NC DEPARTMENT OF
**HEALTH AND
HUMAN SERVICES**

July 3, 2018

Subject: PJ'S Truck Bodies and Equipment – Conditional Approval of Design Daily Flow
1560 George Perry Lee Rd, Dunn, NC
Project Number: 2018-28

Figure 2. Septic System Layout

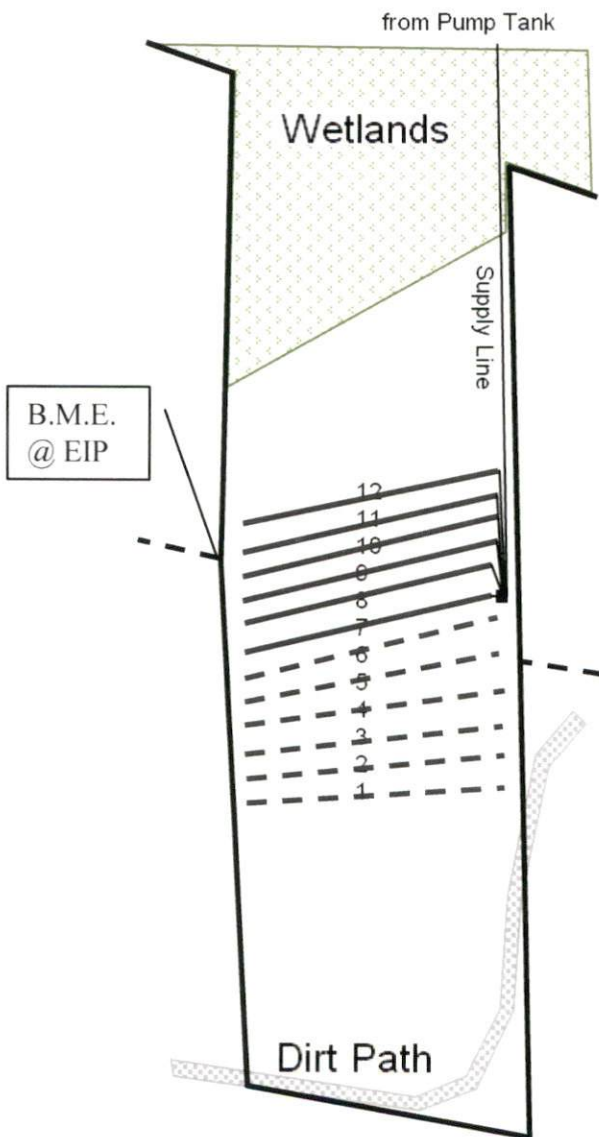
4. New additional tankage as well as new subsurface wastewater dispersal areas (initial and repair) to treat and dispose of a design daily flow of 1,016 gallons is proposed;

6. A six-tap pressure manifold discharging to six (6) 141-foot conventional trenches is proposed for both the initial and repair effluent dispersal.

Review of the information that was provided has been completed and an adjusted design daily flow of 15.7 gpd/employee, which equates to a design daily flow of 1,052 gpd for sixty-seven (67) employees is conditional approved contingent on the following:

1. No showers, floor drains, garbage disposals or grinders as well as no food preparation, HVAC or process wastewater discharge into the wastewater treatment and disposal system;
2. Install an individual water meter or individual accurate wastewater flow measurement method or device on each building;
3. There is no increase wastewater strength to levels above typical domestic strength wastewater; and
4. Chemical cleaners, solvents, petroleum products or any other potentially inhibitory/interfering substance are not permitted for disposal into the wastewater system.
